**Roberts Road Data Centre (SSD-10330)
Response to Submissions**

ATTACHMENT 1

Department Comments

landscape masterplan

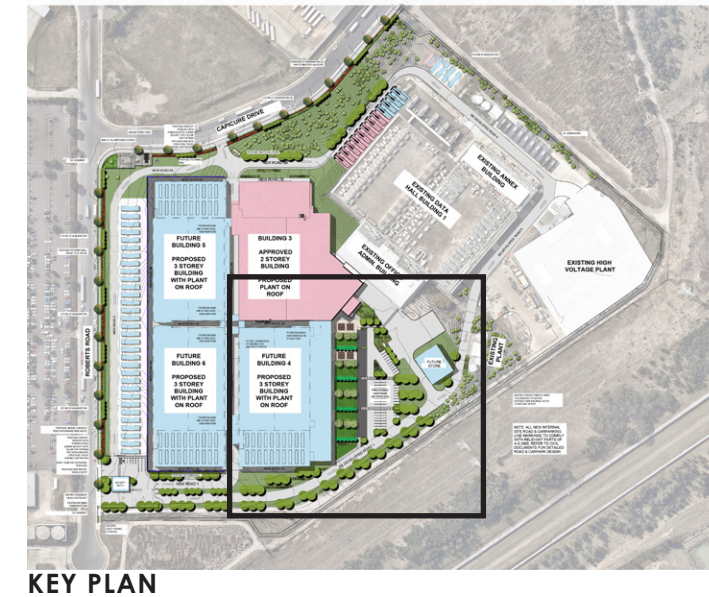
3. Given the comments provided by Blacktown City Council in its submission dated 31 January 2020, please update the landscape masterplan to replace:
 - (i) *Pyrus calleryana* 'Capital' trees with an alternative tree species (either native or exotic) which will provide a larger tree canopy along internal roadways to the north and south of the data centre building
 - (ii) *Elaeocarpus grandis* trees with an alternative tree species (either native or exotic) which is better suited to the local climate.
